Your Ref: OWPC25528
Our Ref: R/12/20/HH 16-01-2020
Please ask for:
Zac Denton

New detached garage
Springfield House Springfield Close Rustington

Thank you for your internet representation made on 27th January 2020 which has been recorded as '**an objection**' with the comments as follows:

Garage - Plan & Elevations

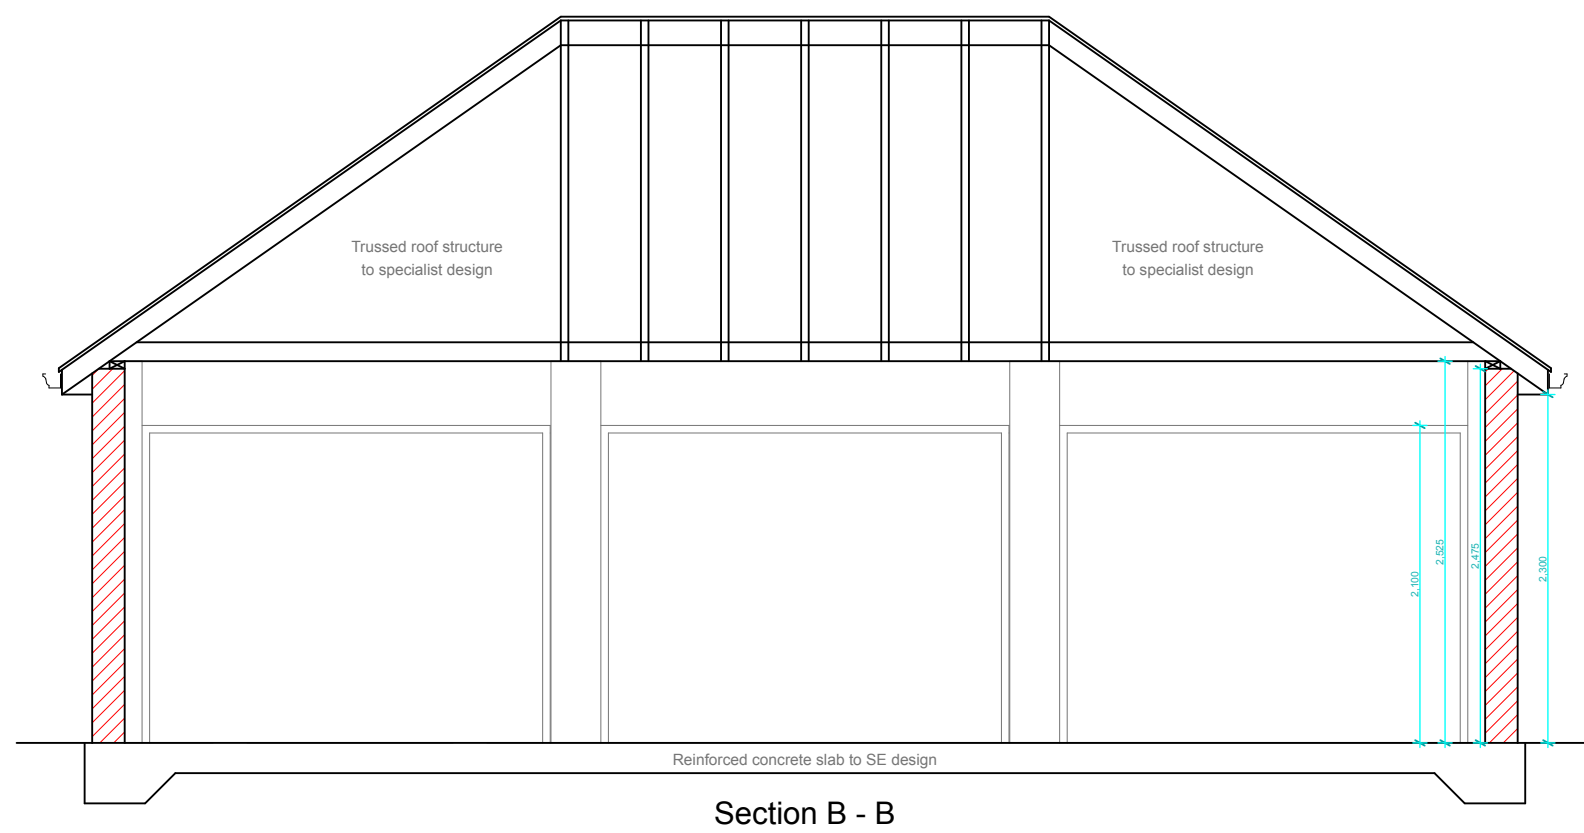
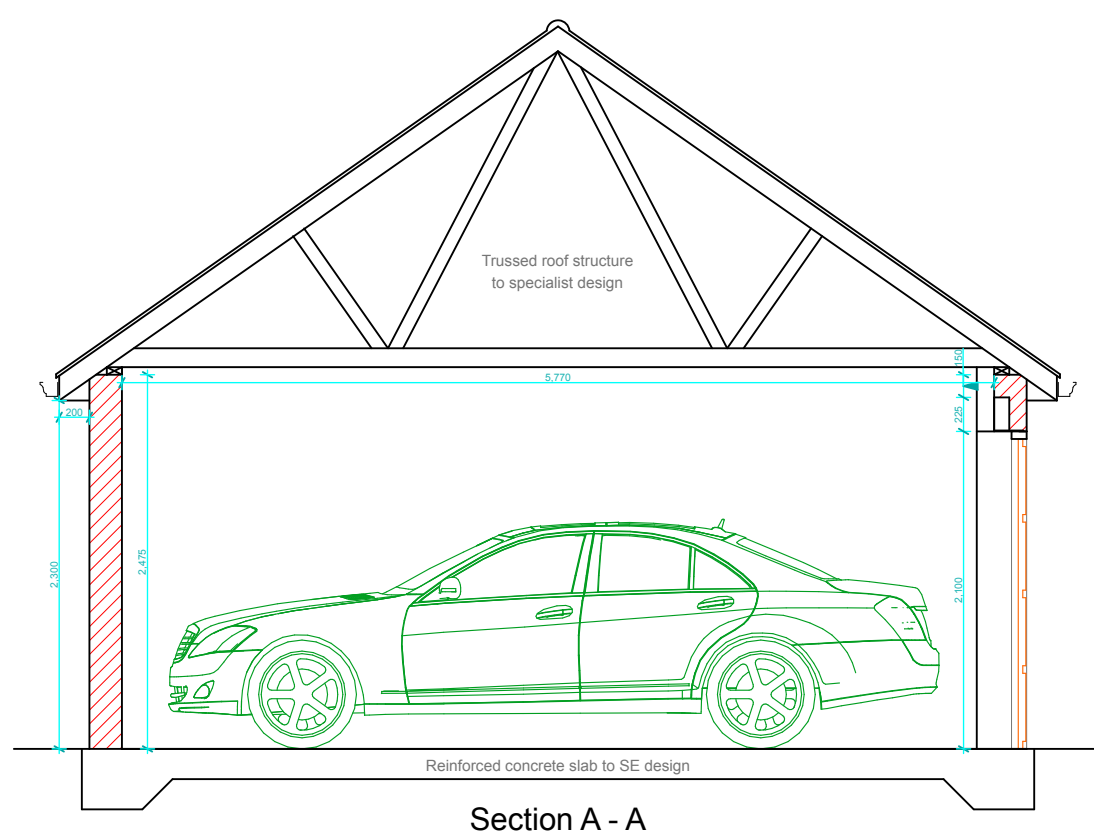
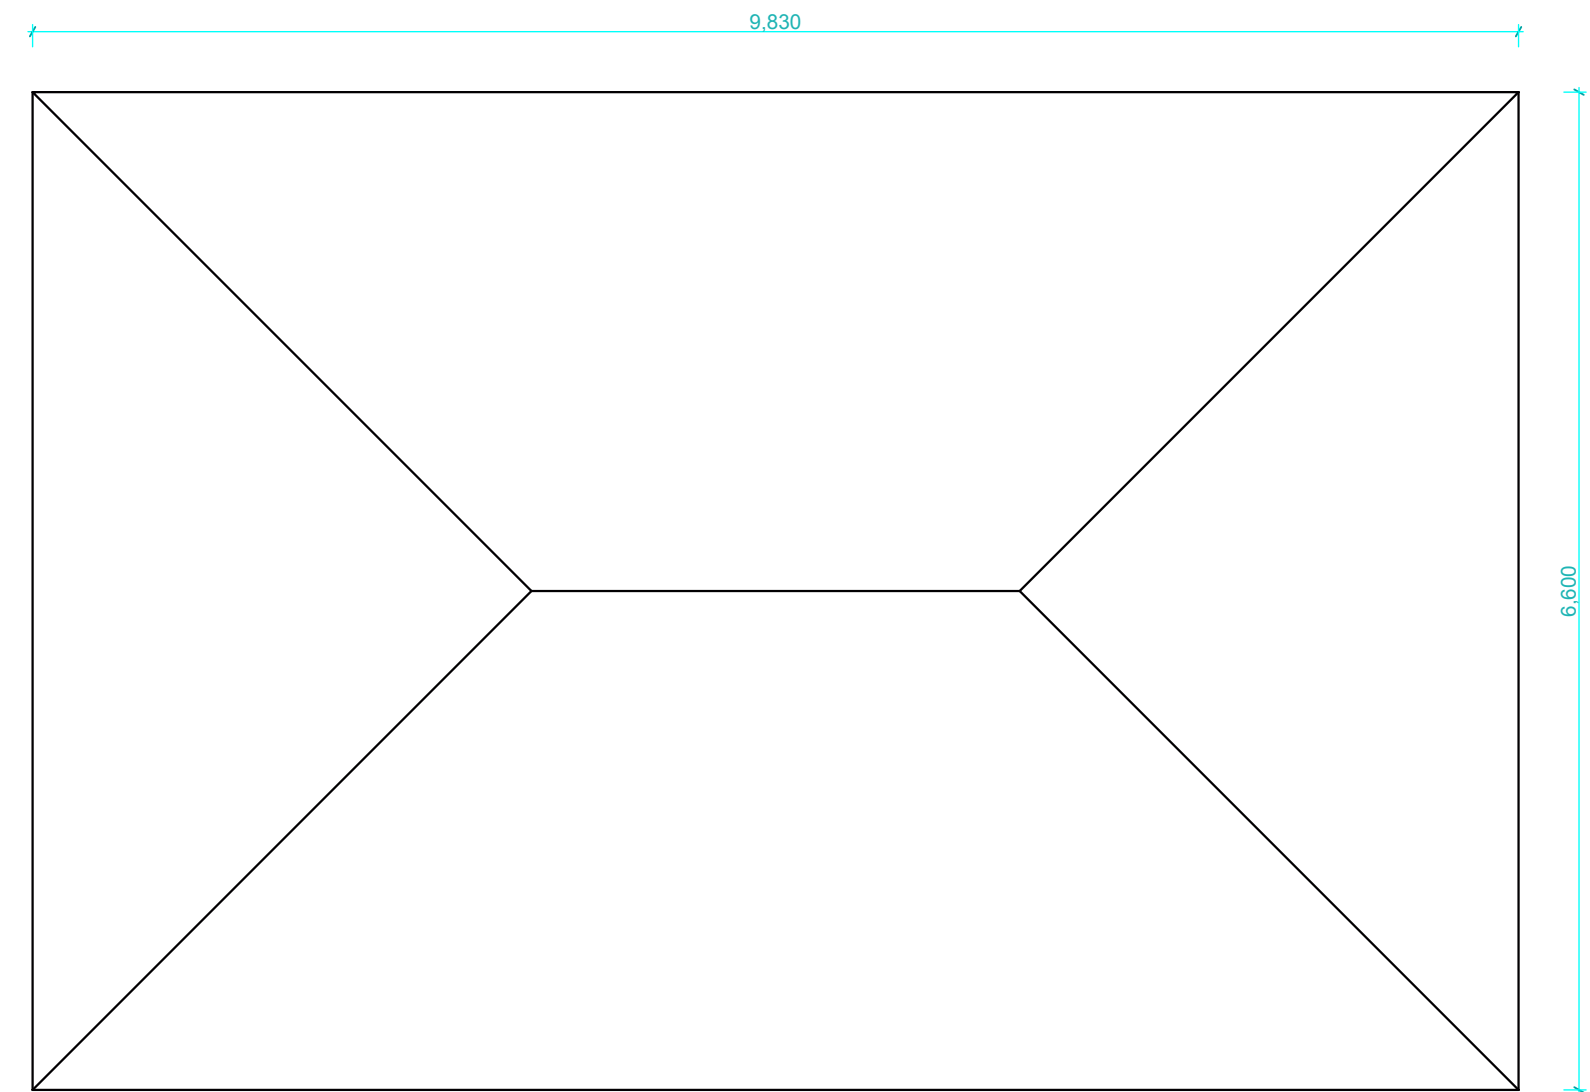
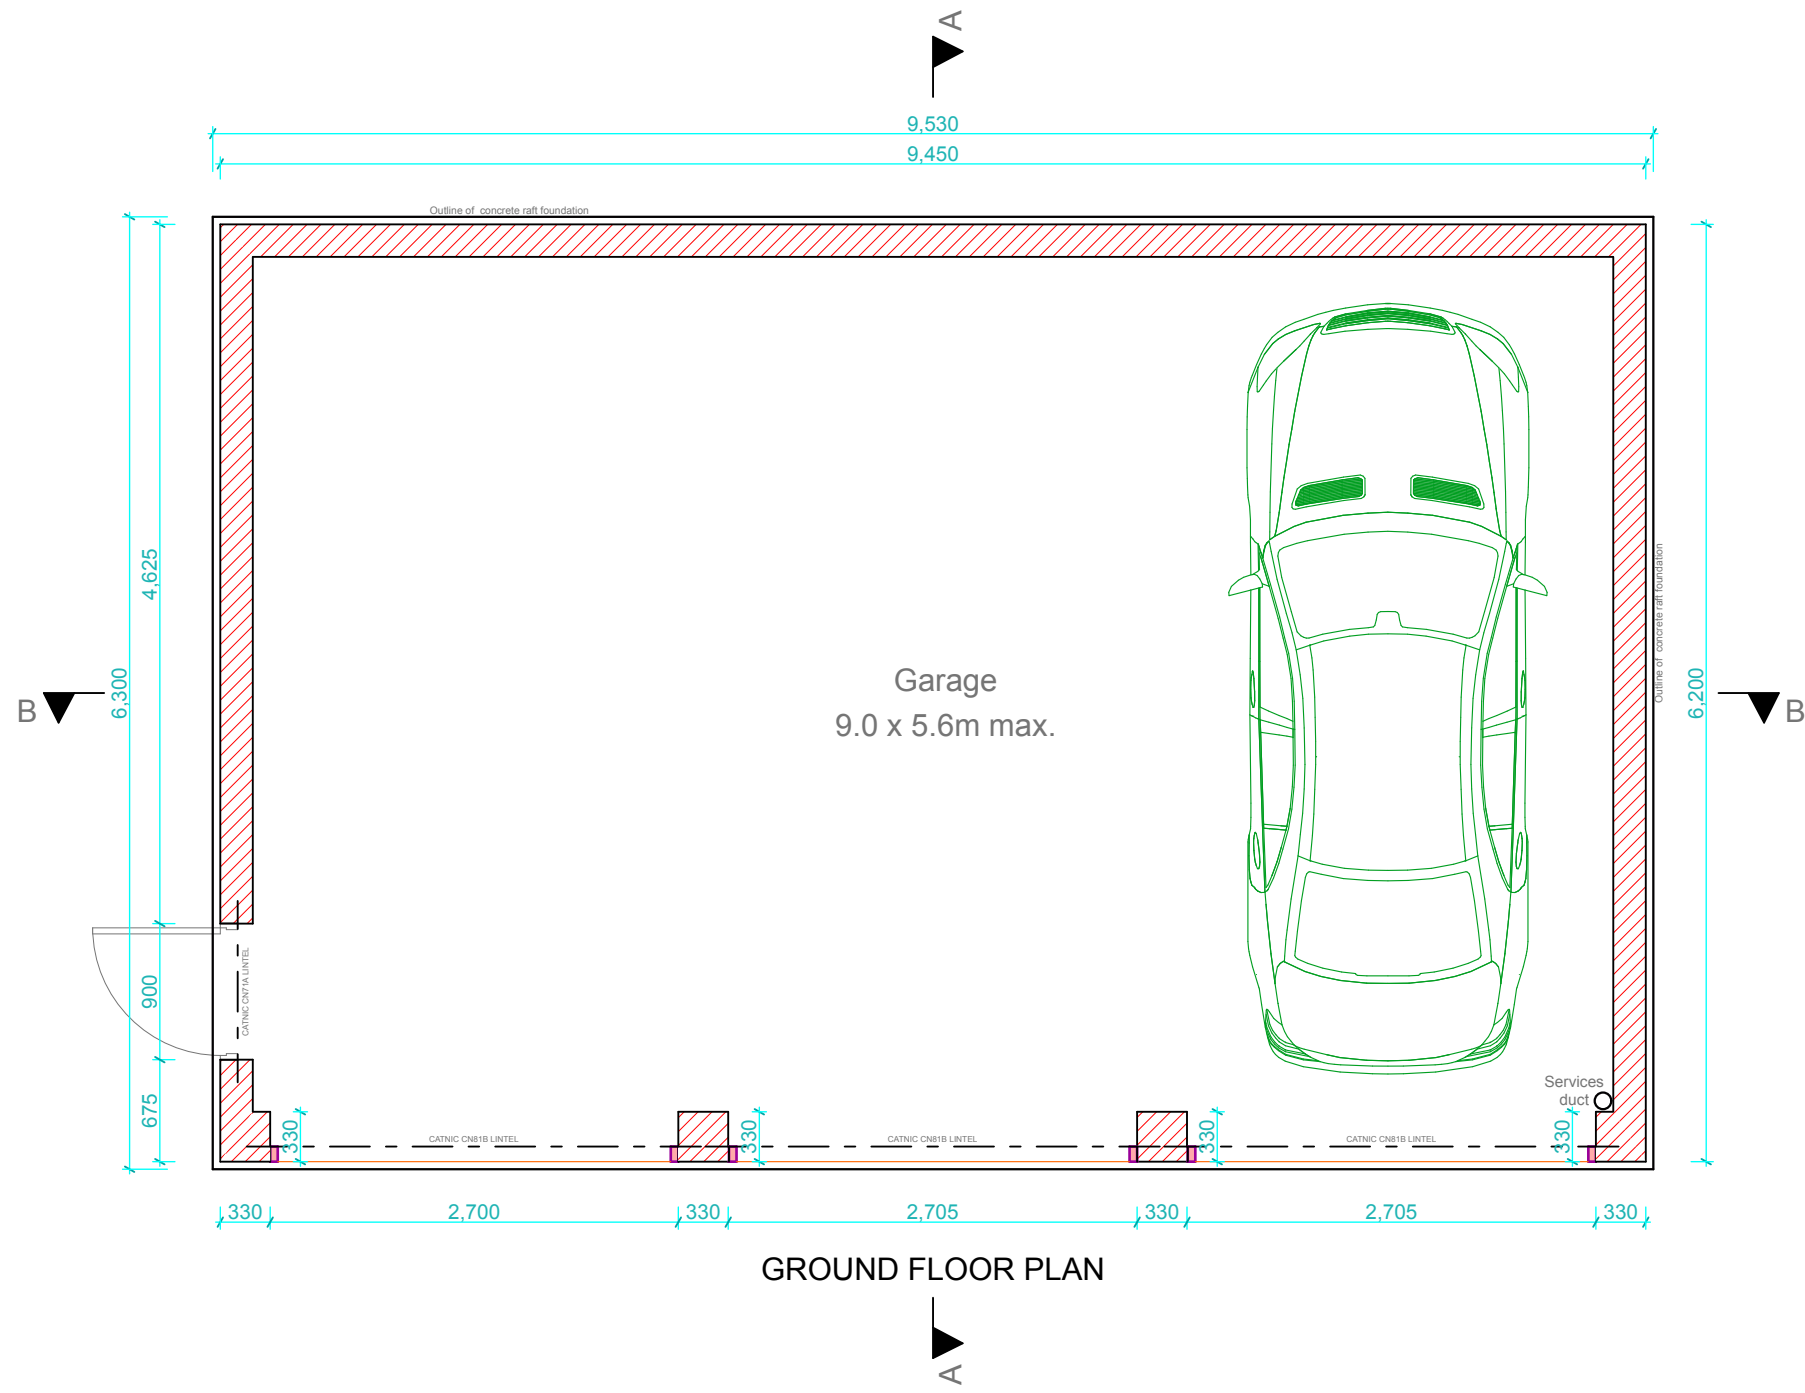
We continue to object to this proposal. The previous Planning Permission located the double garage well away from our western boundary. The proposed position of the garage block will still be highly visible from our garden and if approved it is likely that the applicant will then re-apply for the further accommodation above the garage that was removed as part of the last application.

A triple garage is wholly unnecessary for the size of the approved property. As with the previous application, we believe the triple garage has been shoehorned in to avoid the trees on the northern boundary - however we still believe that trees T16 and T17 will affect the RPAs to a significant extent.

We would ask that this Planning Application is refused or that the triple garage is pushed at least 3 metres to the west to allow for appropriate landscaping to shield this from our property.
